**SSD 9313 Macquarie University New Office and Laboratory Building
8-12 University Avenue, Macquarie University**

Thank you for your email dated 14 January 2019 inviting Transport for NSW (TfNSW) to review and comment on the subject proposal.

The documentation in support of the proposal has been reviewed and the comments are provided in details as outlined in **Attachment A**. The recommended conditions of consent are provided in **Attachment B** for consideration.

Drawing
SITE PLAN

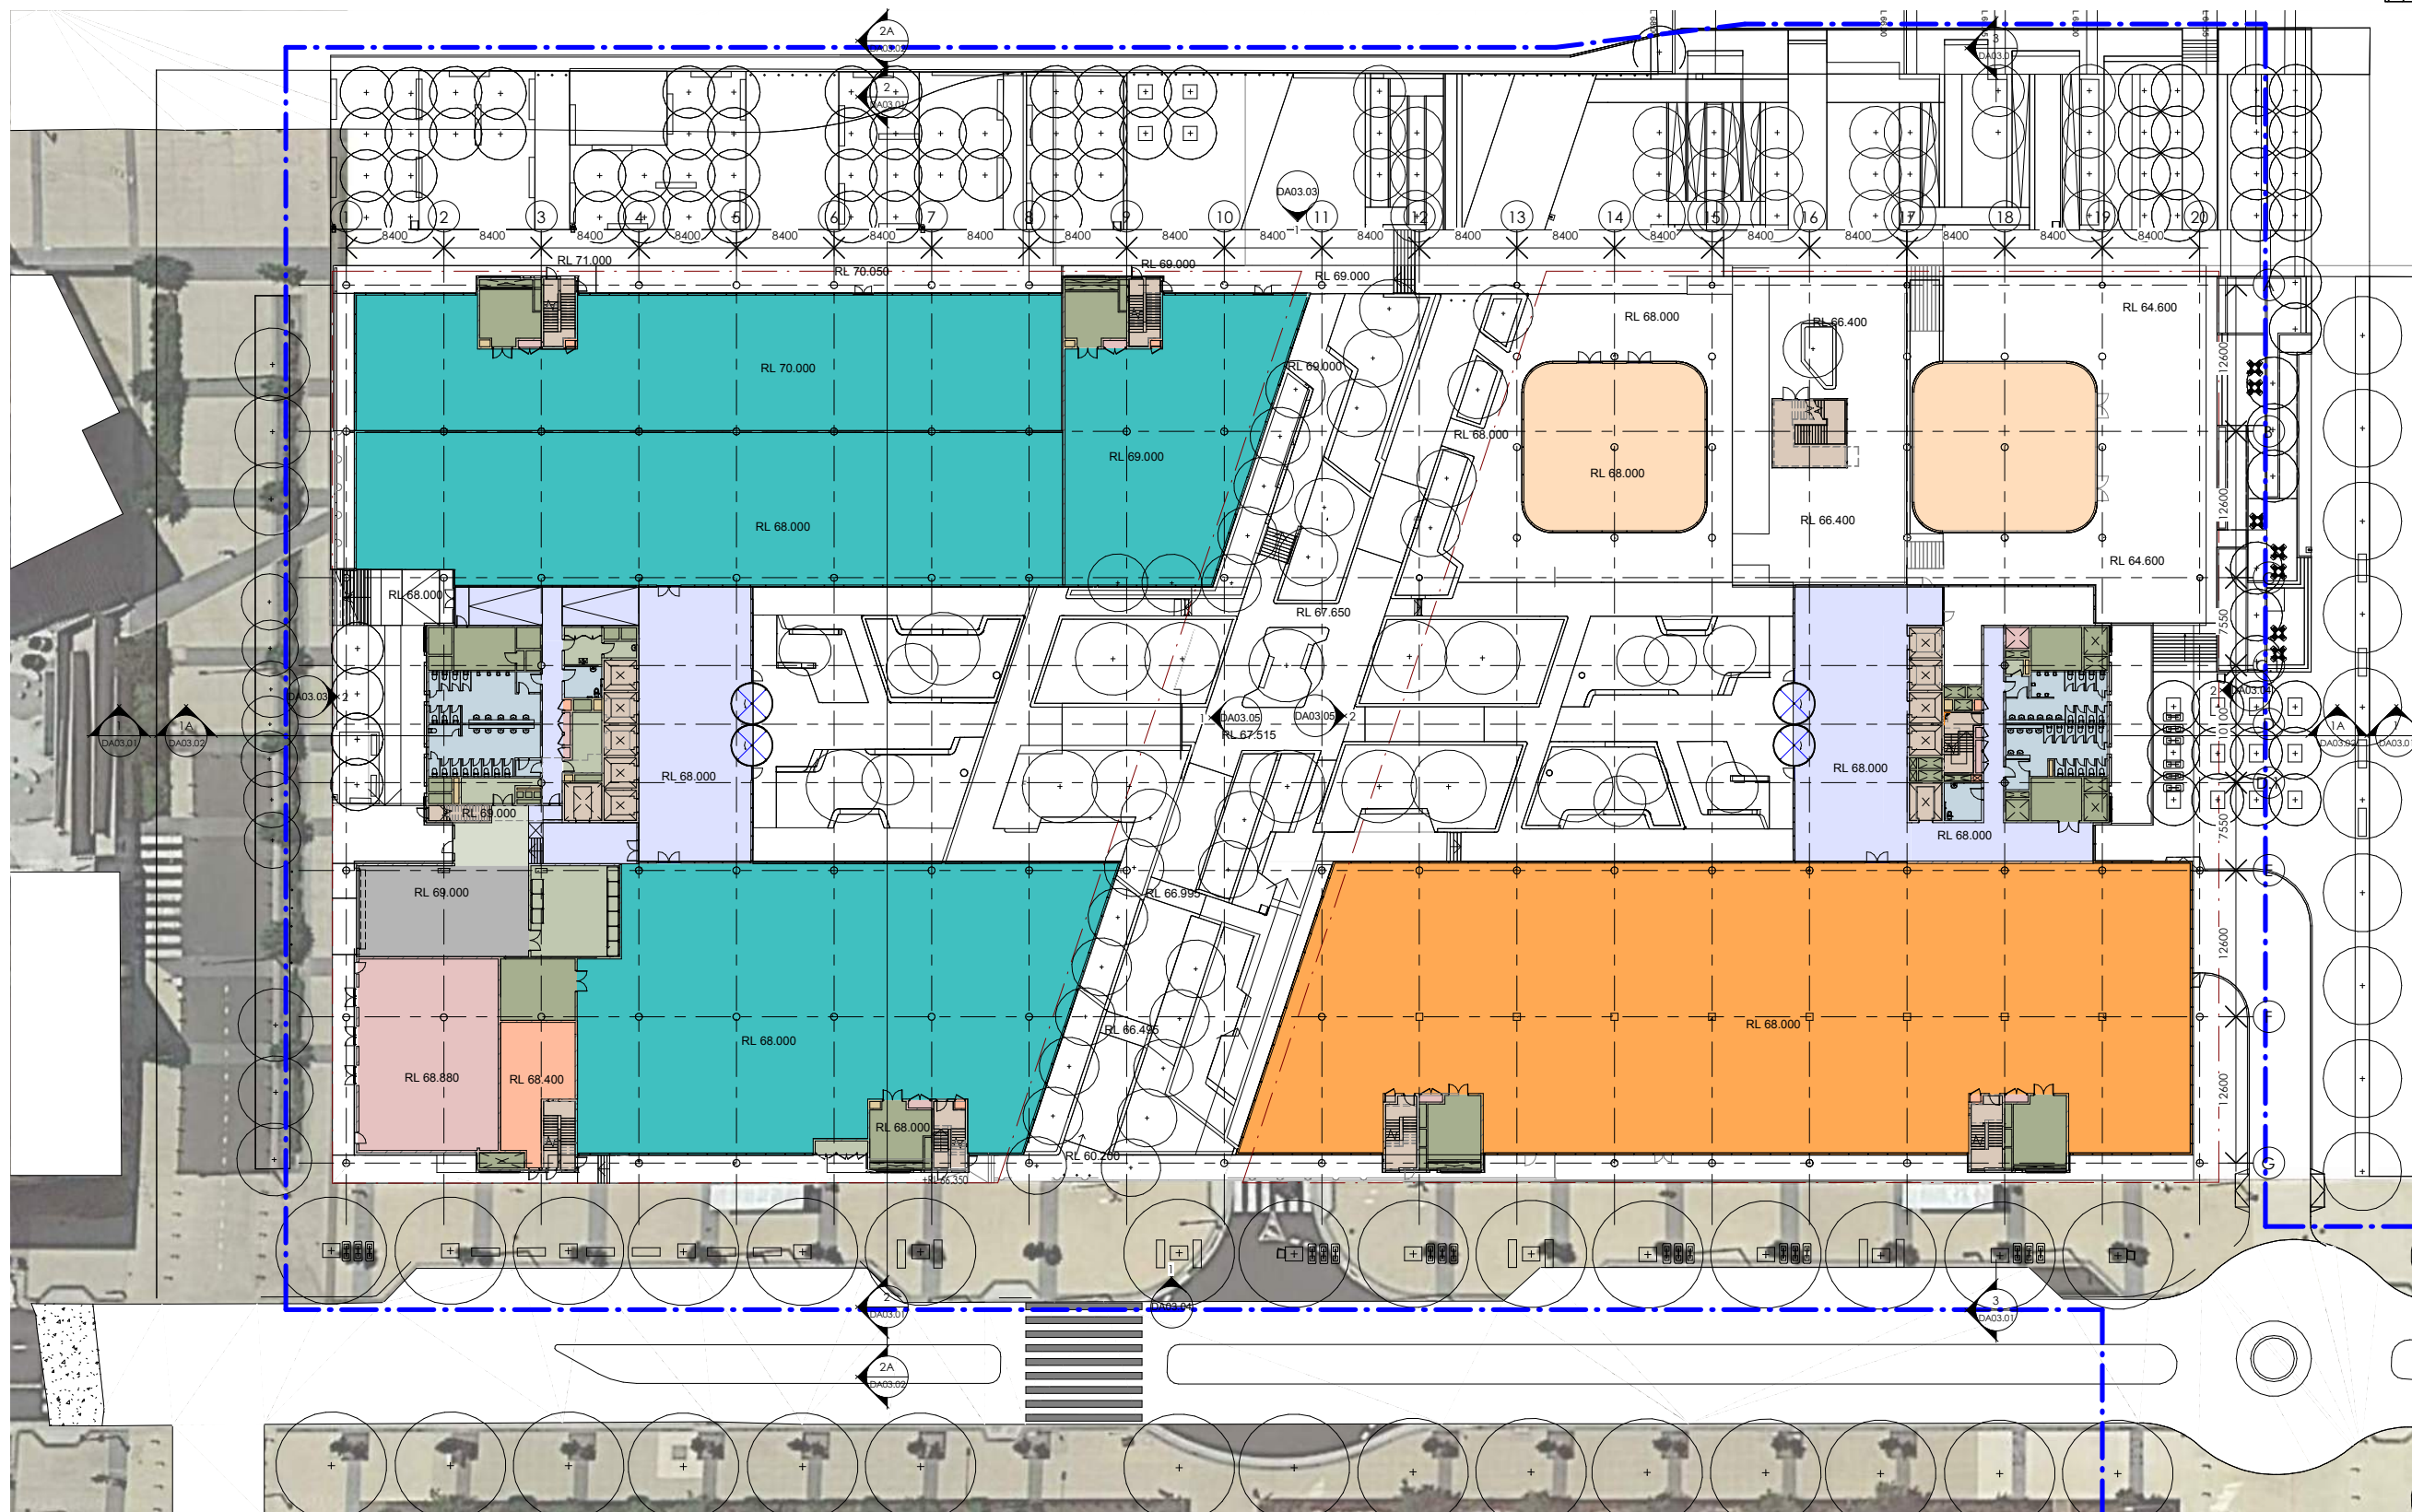
Section 4.5 of the Transport Assessment report indicates that cars enter the basement car park via the existing roundabout on University Avenue at the eastern end of the site. However, in Section 5.3 and Figure 15 of the report, it is indicated that a new roundabout would be provided at the site access point at the eastern end of the site whereas there is no indication of changes would be made to the existing roundabout where University Avenue and Research Park Drive meet. This information is not consistent with that shown in the DA drawings.

It is requested that the above be clarified and documentation revised as necessary.
